Re: Existing Tank Inspection HTE #08-5-19792

Based on the criteria set out in Title 15A, Subchapter 18A, of the North Carolina Administrative Code, Rules .1950, the evaluation indicated that the site is **UNSUITABLE** for the addition requested. Therefore, your request for an existing tank is **DENIED**. The site is denied based on the following:

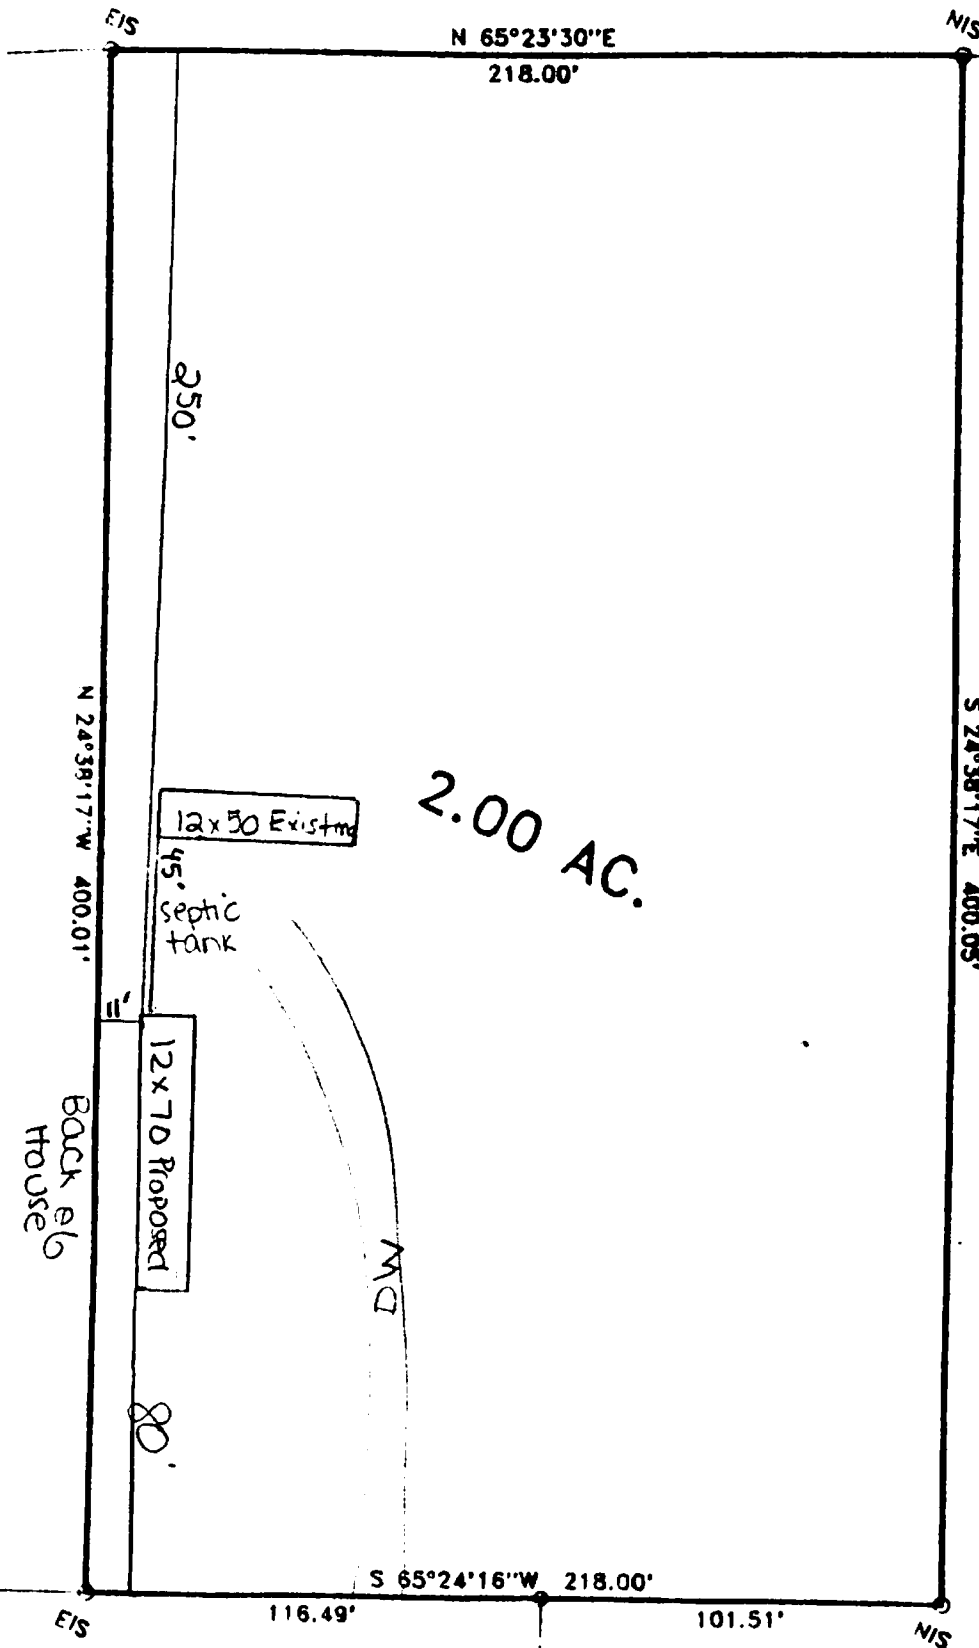
- 15A NCAC 18A.1950 a(16) Any swimming pool must be 15' from any part of septic system.
- 15A NCAC 18.1945 (b) Each lot shall have original septic system plus repair area.
- 15A NCAC 18A.1950 (10) – Any building to be 5' from drain line.

**Your proposed home location is on top of your septic system, and therefore cannot be approved. Your option is to move the proposed home site off of septic area - (marked by my red flags) and submit a new plot plan to Central Permitting. You will need to uncover the outlet end of tank as (marked by white flag). Please note that septic system is designed for one home only.**
